Your Ref: OWPC23746
Our Ref: K/19/19/HH 25-06-2019
Please ask for:
Zac Denton

Two storey rear extension with a small canopy projecting the footprint to the front.
Demolition of existing living room and additional first floor for habitable use with alterations to fenestration.

Little Tangle Middle Way Kingston Gorse East Preston

Thank you for your internet representation made on 23rd July 2019 which has been recorded as '**an objection**' with the comments as follows:

Drawing Title
Proposed Sections

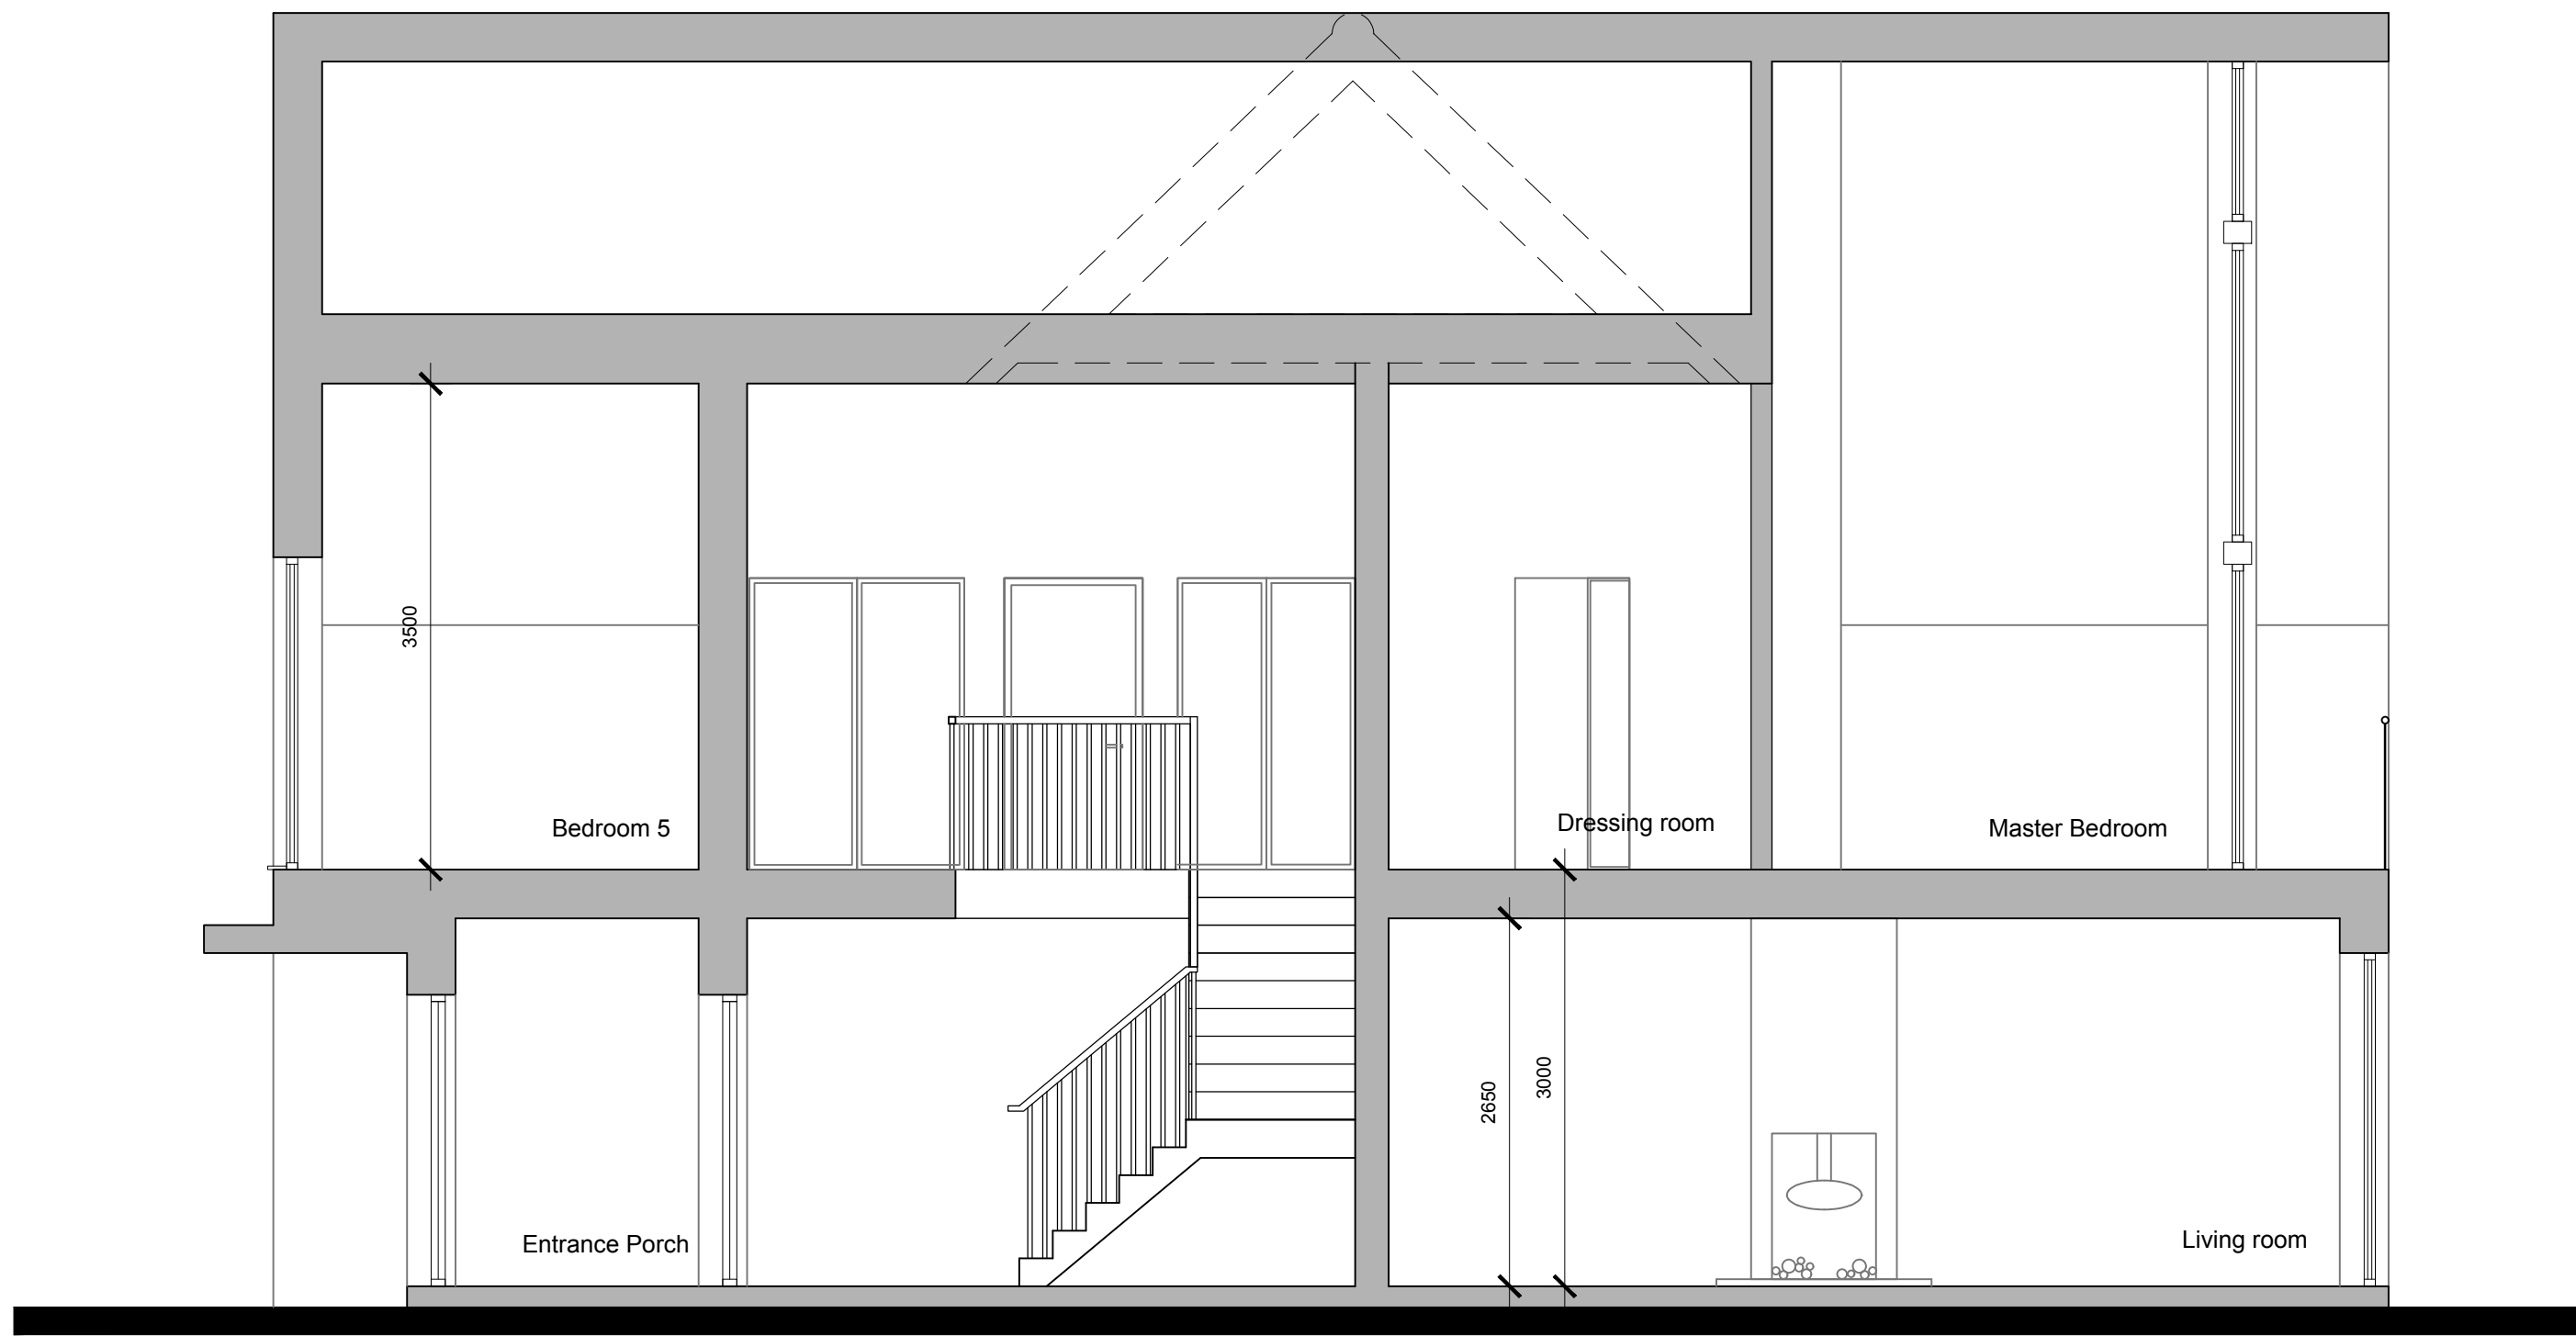
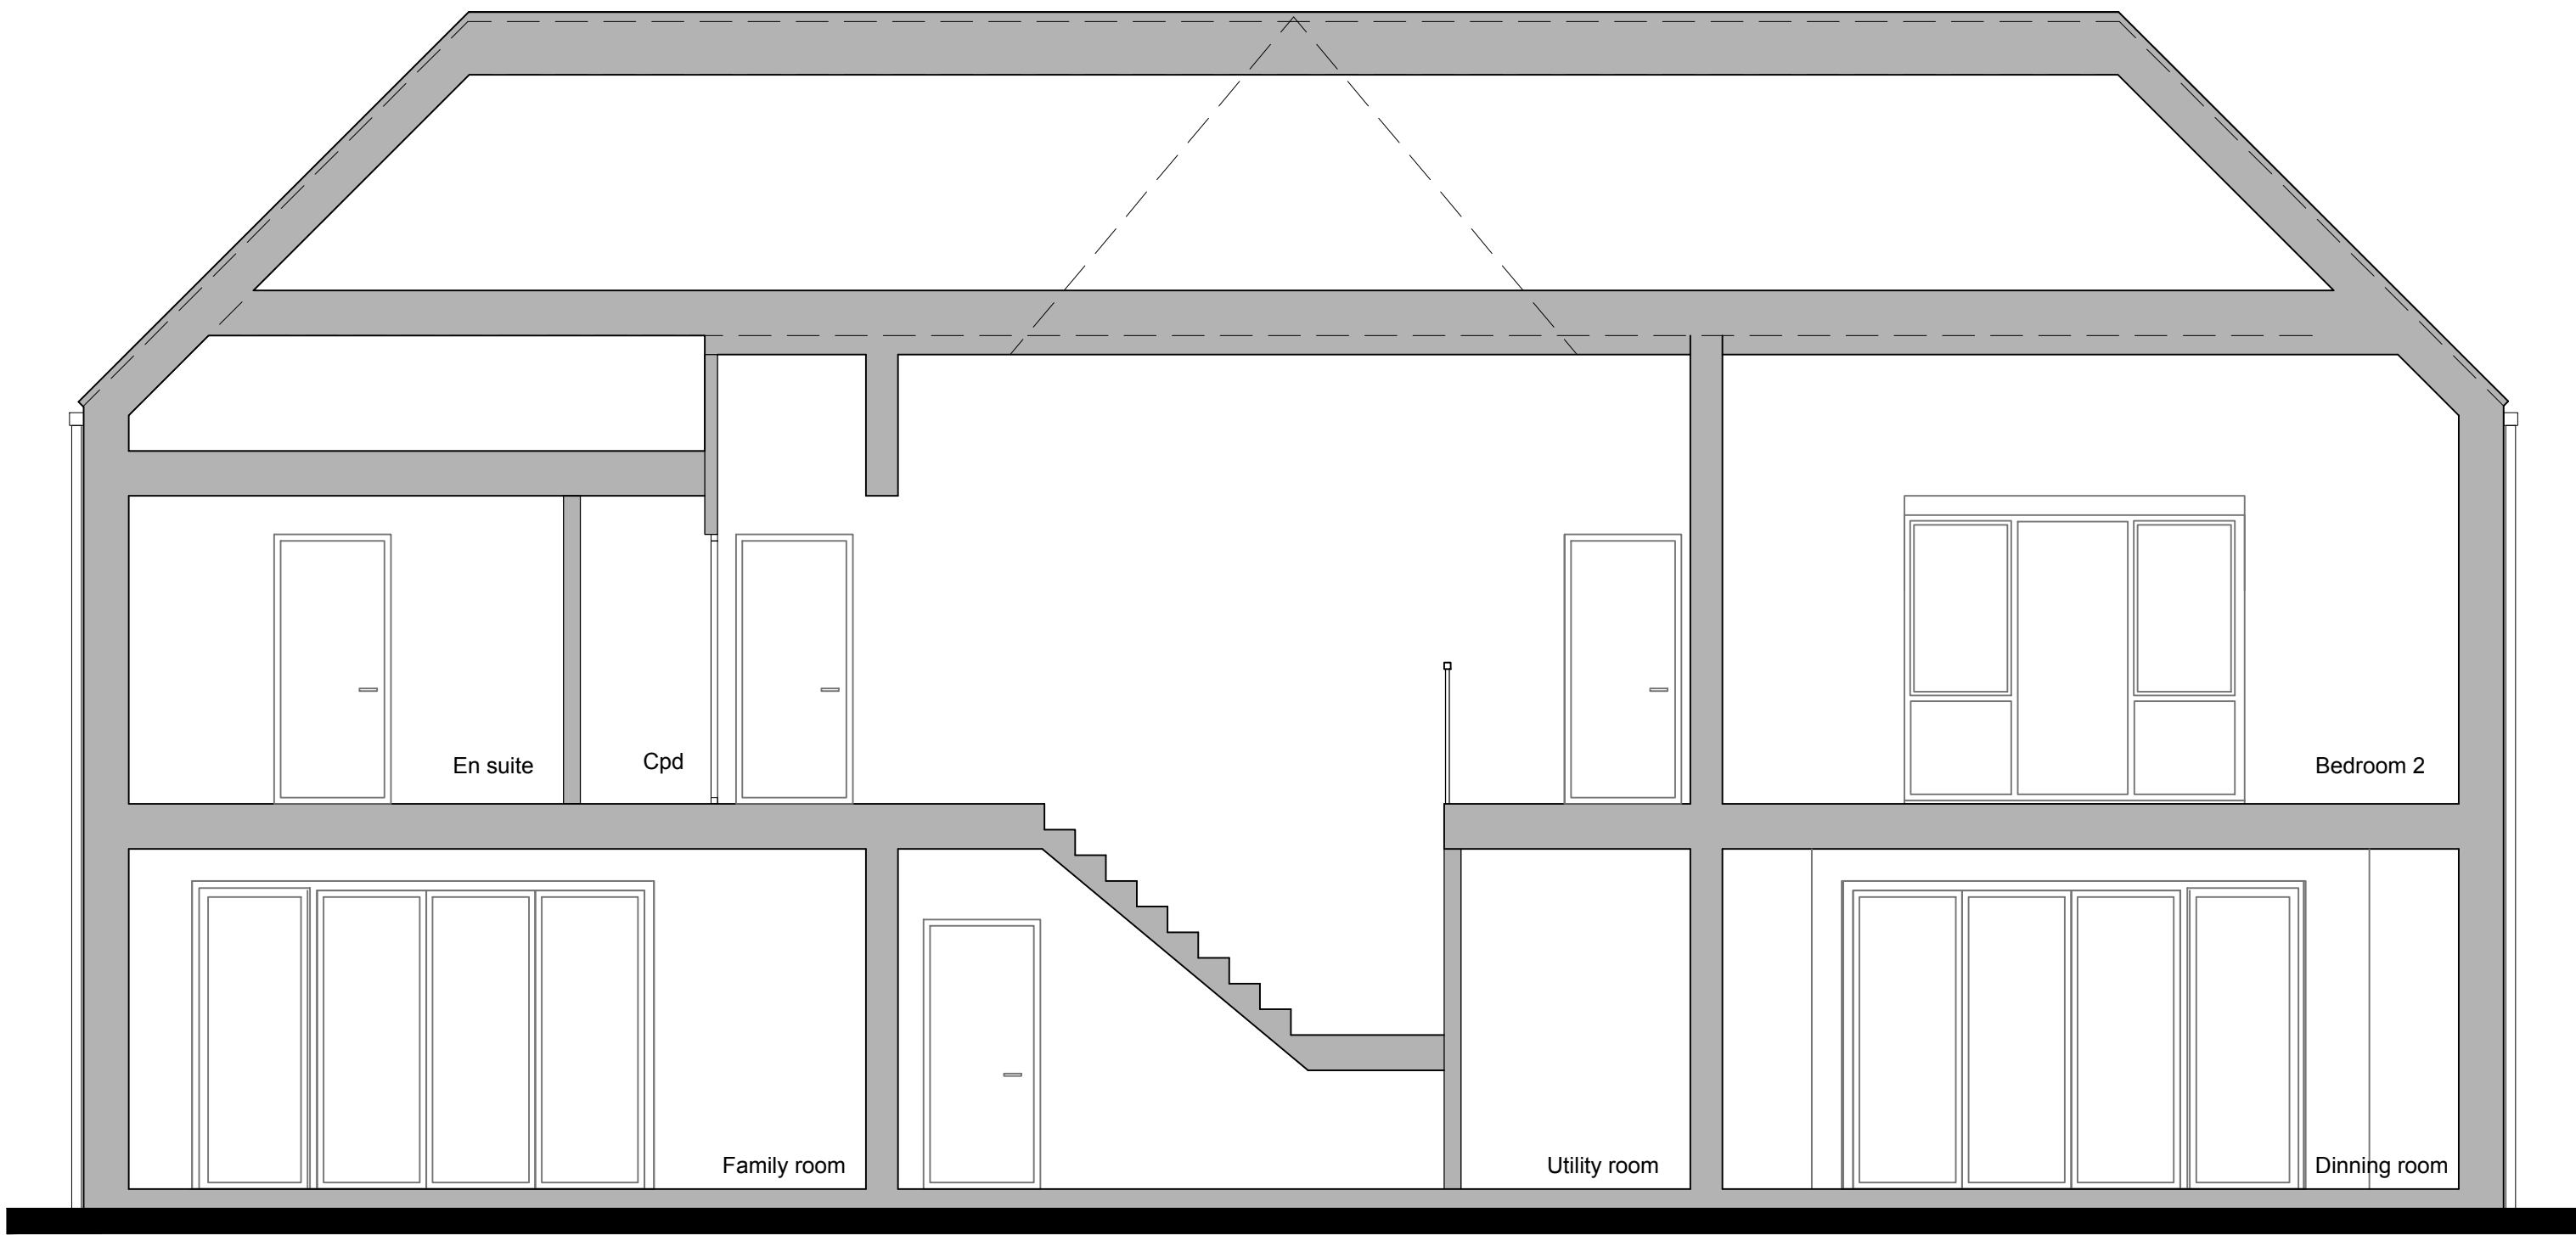
2. The building ridge height is currently c12m and the proposed ridge height is c15.4m, an increase of 3.4m (a 28% increase). Our ridge height is 13.4m.

It is unclear how such a significant increase in the ridge height can be considered as an extension. The 2018 planning application for The Poynings required our small side extension (which did not overlook the neighbouring property) be subservient to the existing building. This required the extension ridge height to be reduced to 50cm below the existing. This resulted in a material compromise in the upstairs extension creating a very low skilling 50cm lower than was anticipated.

If the planning rules are applied consistently the maximum ridge height for this extension, should be c11.5m.

3. The ground floor m2 footprint is unchanged but the shape of the footprint is different. The proposed rear development extends the footprint beyond the current building line and that of The Poynings. It would be a 2-storey extension 3.4m higher than it is today and 2m higher than The Poynings.

We believe the rear balcony gable would extend at least 1.5m beyond the line of The Poynings.
